**KIRKLEES METROPOLITAN COUNCIL
INVESTMENT & REGENERATION SERVICE**

DELEGATED DECISION TO DETERMINE PLANNING APPLICATIONS

Reference No: 2020/62/93868/W

Description: Erection of single and two storey extensions

EXISTING AND PROPOSED SITE
PLANS

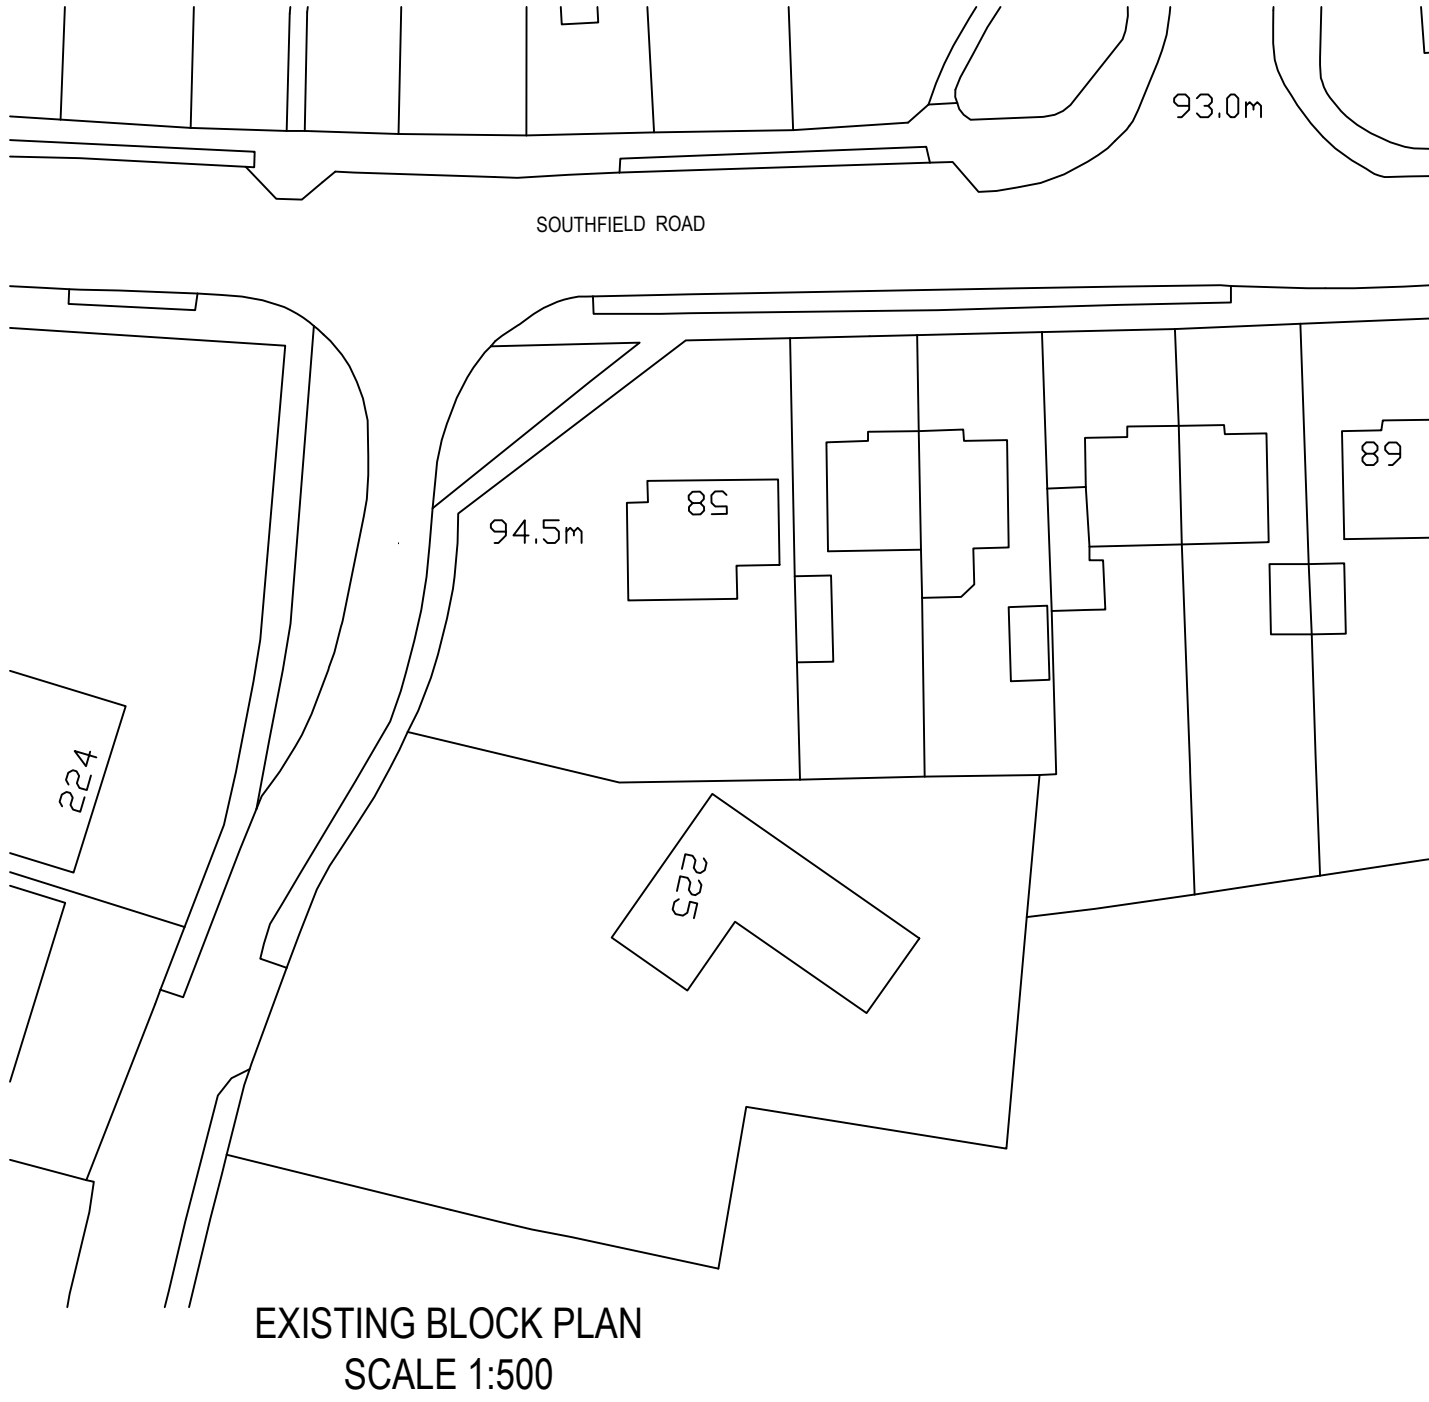
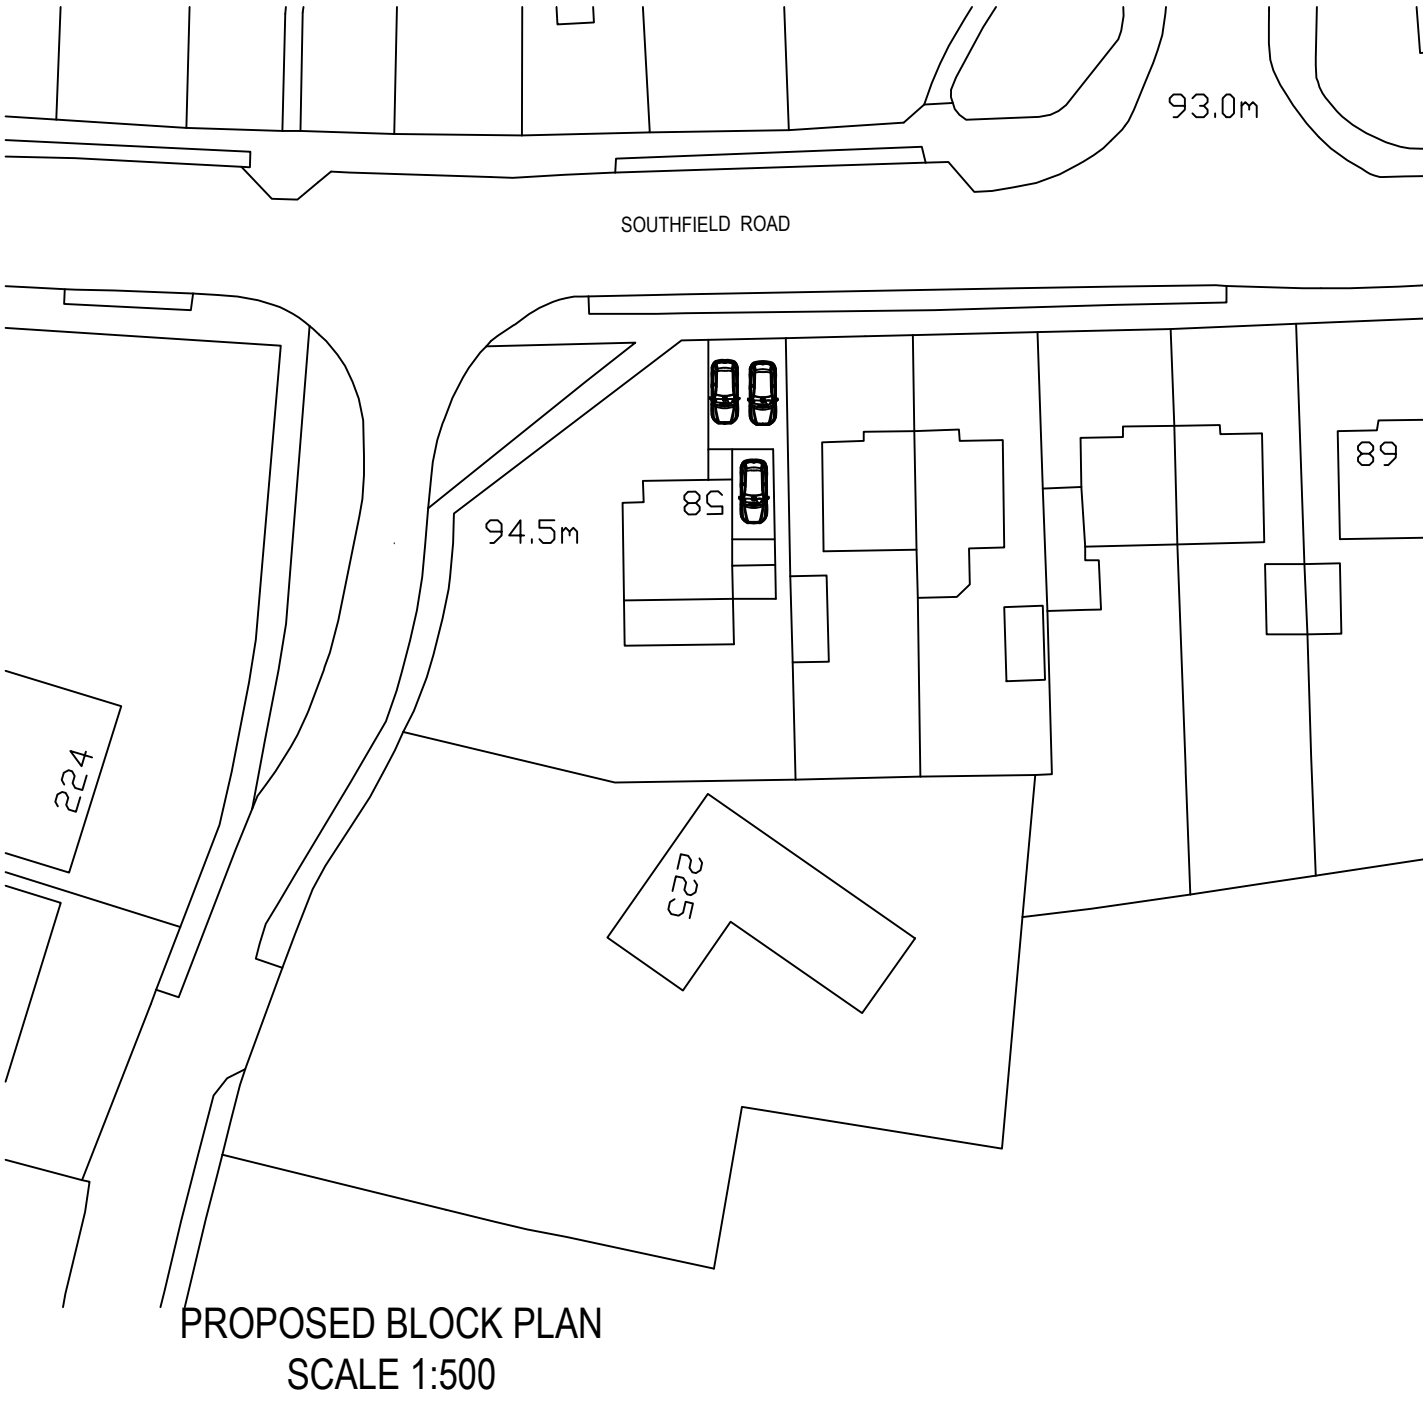
The case officer requested amended plans to increase the extent of parking available at the property. This was in line with K.C. highways guidance due to the proposed increased number of bedrooms to the property following development. Amended plans were received, showing an extension to the front driveway of the property.

Additionally, to the front elevation some of the front garden will be excavated and part of the boundary treatment removed to facilitate additional parking at the property. This is deemed necessary due to the increase in the number of bedrooms from the proposed development. The loss of some front garden amenity space will not be detrimental with regard to visual amenity because the loss is minor in extent and the front garden is large in size and therefore, there will be a continued presence of front garden space to the front elevation of the dwelling following development.

It has been acknowledged that there would be no detrimental impact upon highway safety as the proposal will increase the extent of existing parking arrangements at the property. Amended plans show the driveway increased to facilitate 2 car parking spaces on the driveway with a third within the garage. Highway access to and from the property is generally as existing and not altered significantly as a result of the proposal. 3 car parking spaces are considered adequate for the development that increases the number of bedrooms to the property. For these reasons, the proposal is considered to comply with Policies LP21 and LP22 of the Kirklees Local Plan.
